A57 Link Roads

TR010034

**9.72 Addendum to the Statement of
Common Ground with High Peak**

March 2022

**6.4 Environmental Statement  
Figure 5.4 Air Quality EU Compliance Risk  
Assessment**

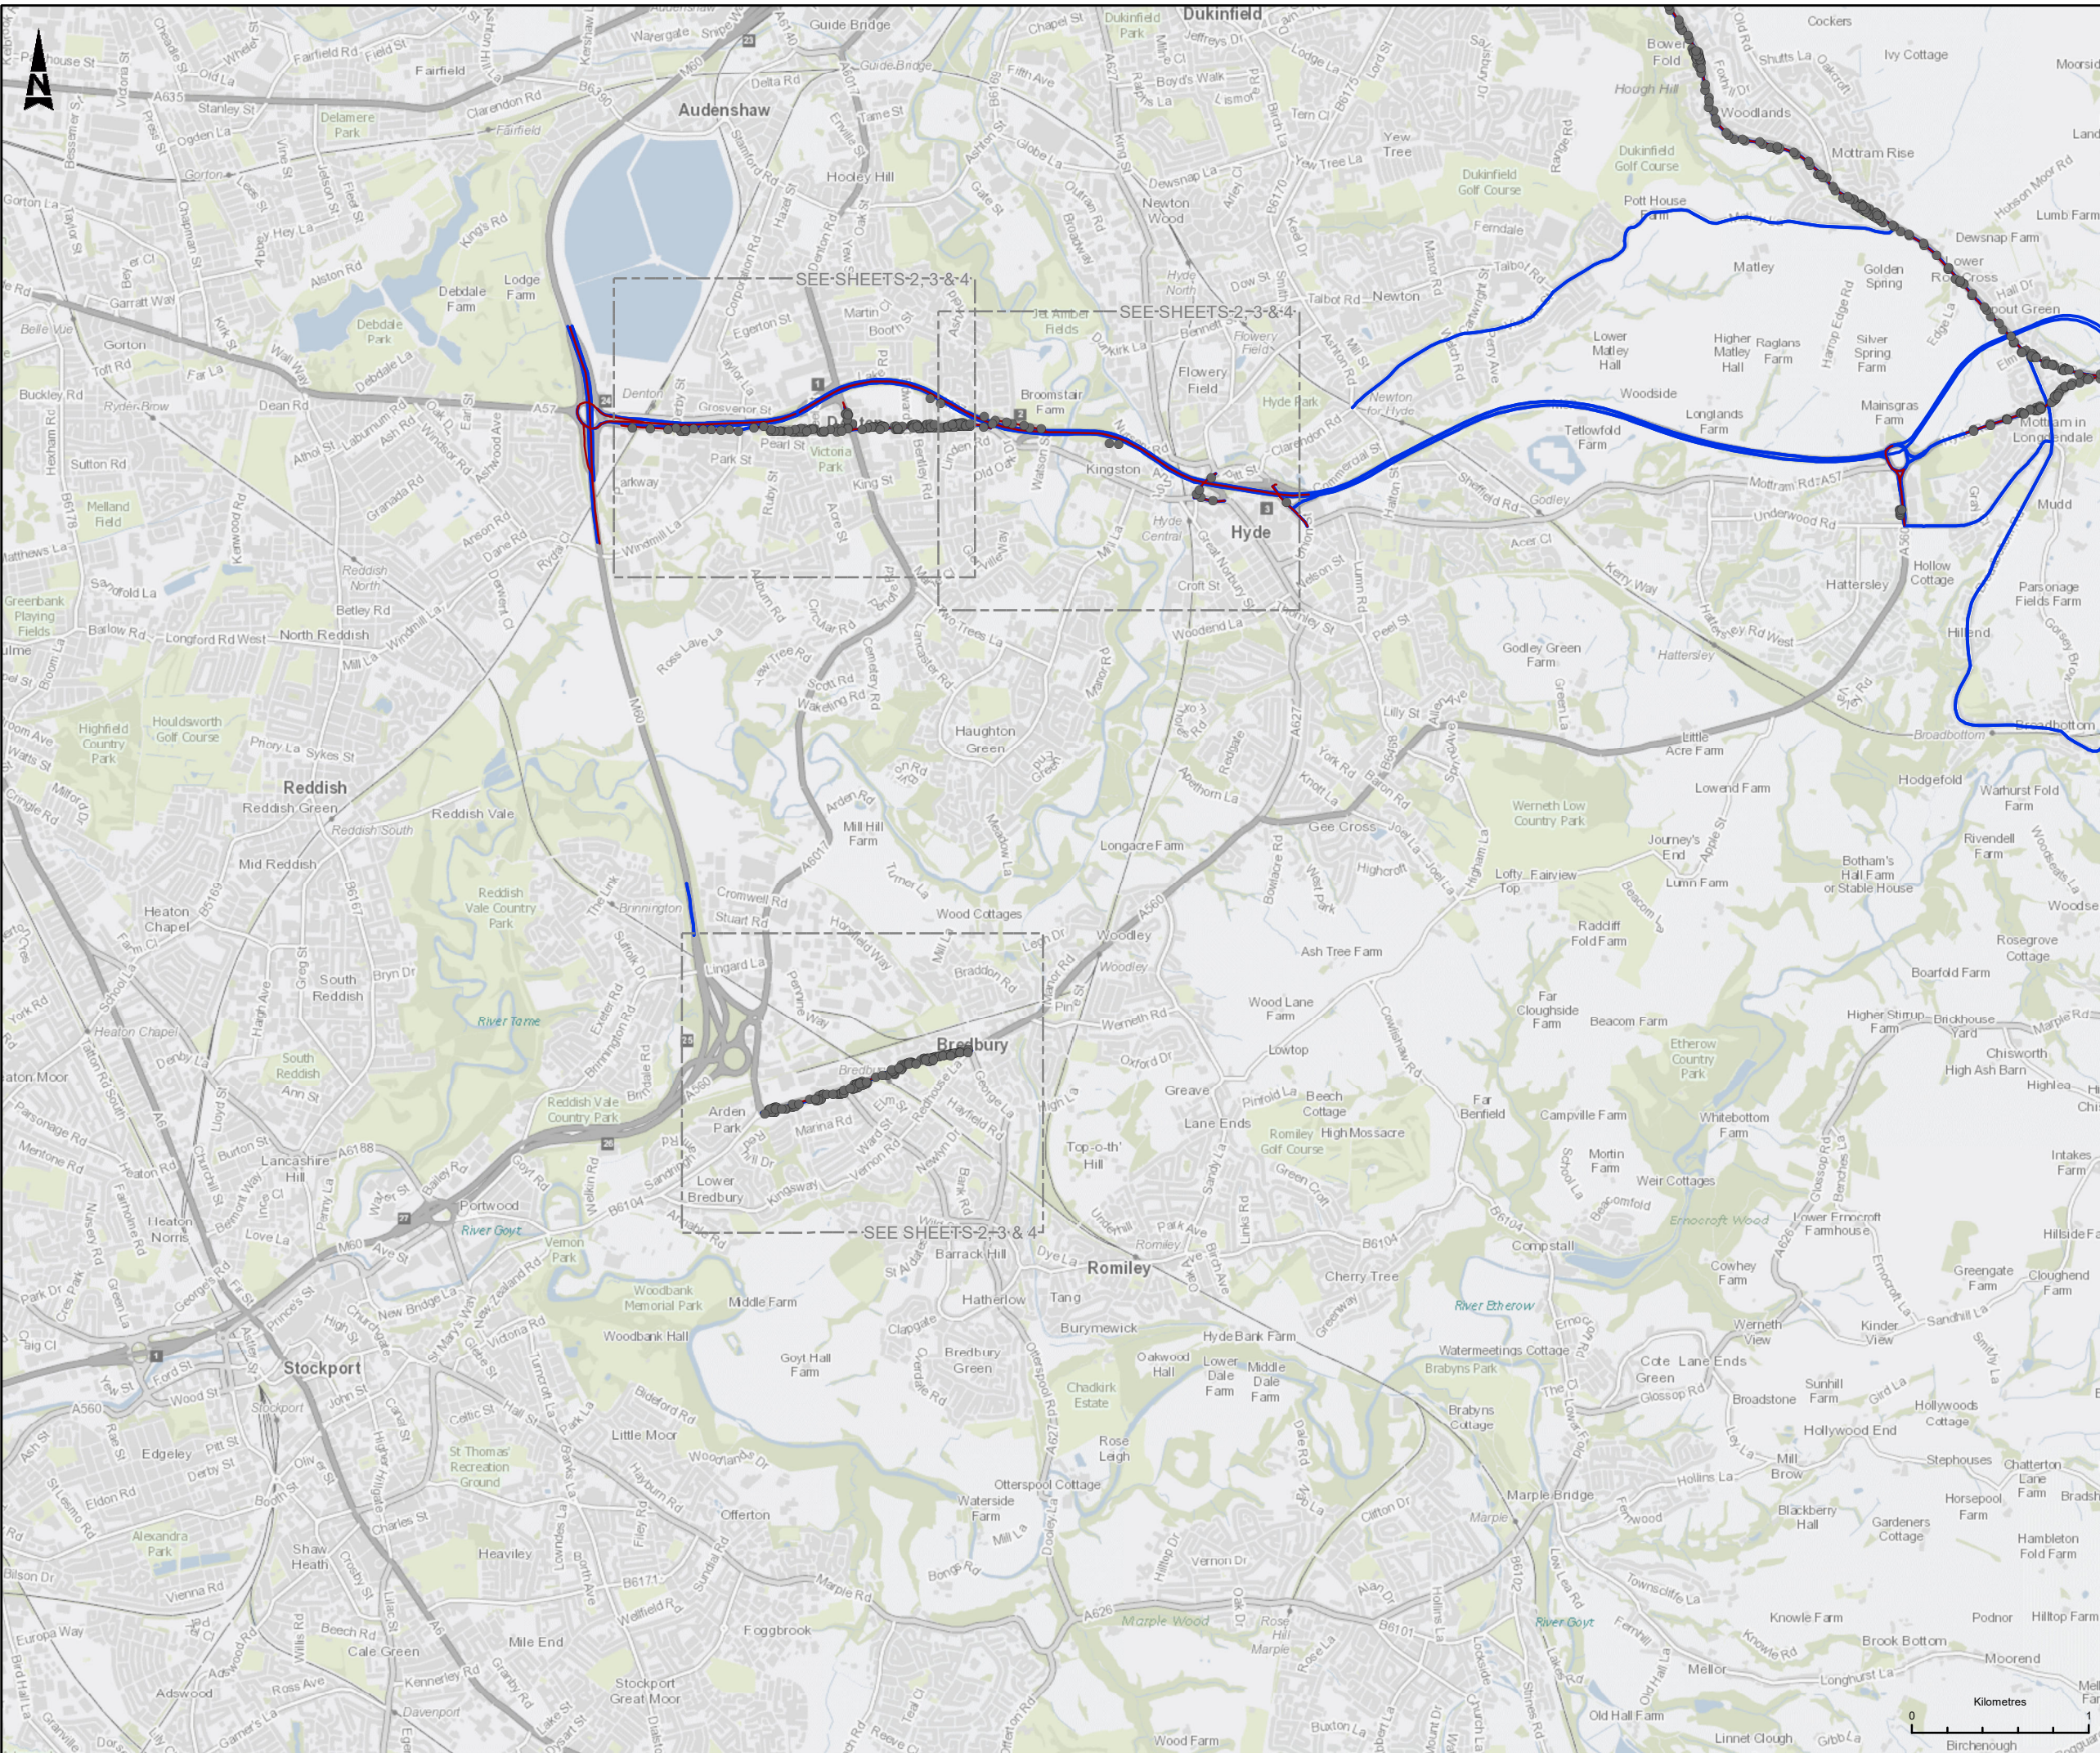
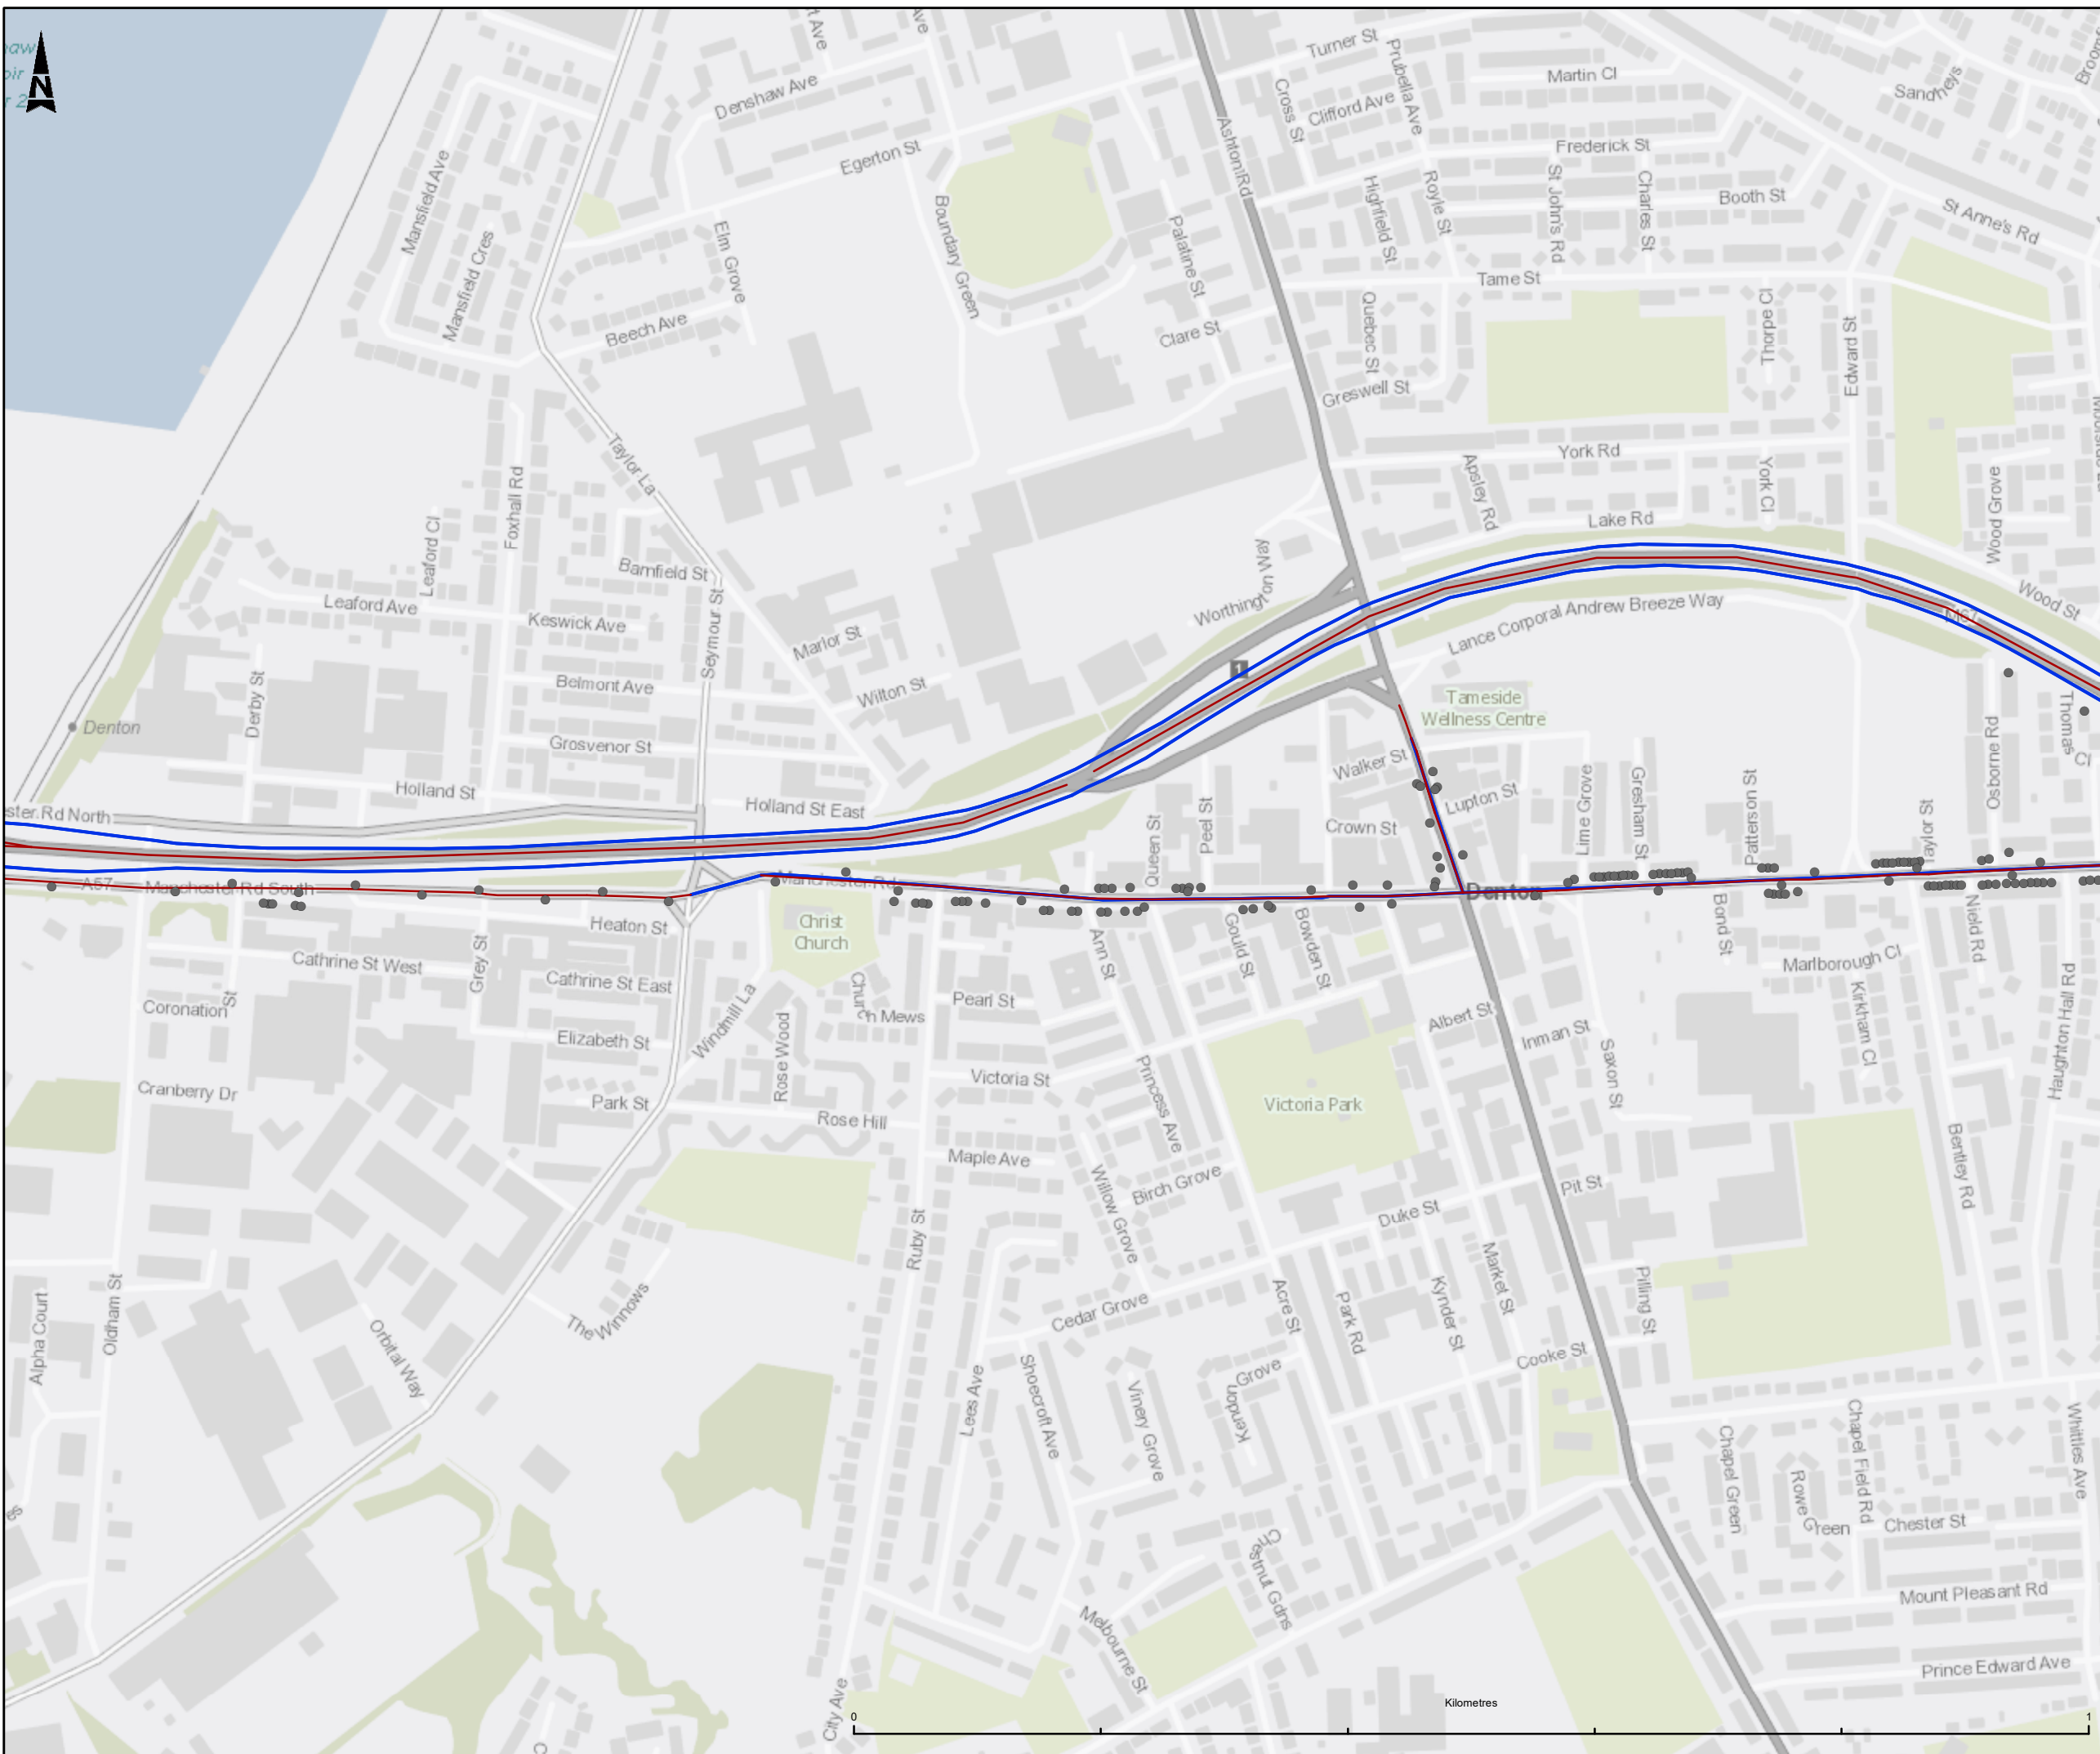
Figure 5.4 Air Quality Compliance Risk Assessment – receptor labels			
<p>Item 8.38 HPBC [REP4-011] asked for the A57 Brookfield qualifying features used in</p>	<p>Given the number of qualifying features and public access receptors included in the compliance assessment it was not</p>	<p>Agreed</p>	<p>Closed</p>

HPBC Item	National Highways Position	HPBC Position	Status
<p>the NO2 compliance assessment to be labelled on ES Figure 5.4 [APP-080].</p>	<p>possible to practically label the qualifying features in ES Figure 5.4 (APP-080) however, an extract of ES Figure 5.4 zoomed in on the A57 Brookfield area with receptor ID labels for qualifying features and public access receptors adjacent to the A57 Brookfield is provided below this table.</p>		
<p>Adjustment of Background Concentrations Data used in Air Quality Assessment</p>			
<p>Item 8.39 HPBC raised concerns about the lack of adjustment to the background concentrations used in the air quality assessment. HPBC [REP4-011] suggest they are concerned about over representation of beneficial effects.</p>	<p>The HPBC query relates to the verification and adjustment of the Department for Environment, Food and Rural Affairs (Defra) mapped background concentrations. National Highways provided a response to question 8.39 in REP3-018. As stated in REP3-018, where the Defra background maps underpredict background monitoring data this could lead to a need to apply a higher adjustment factor in the air quality model verification. The higher the adjustment factor applied, the more conservative the results of the assessment given that the adjustment is applied to both the modelled total concentration with and without the Scheme, which has the</p>	<p>Agreed</p>	<p>Closed</p>
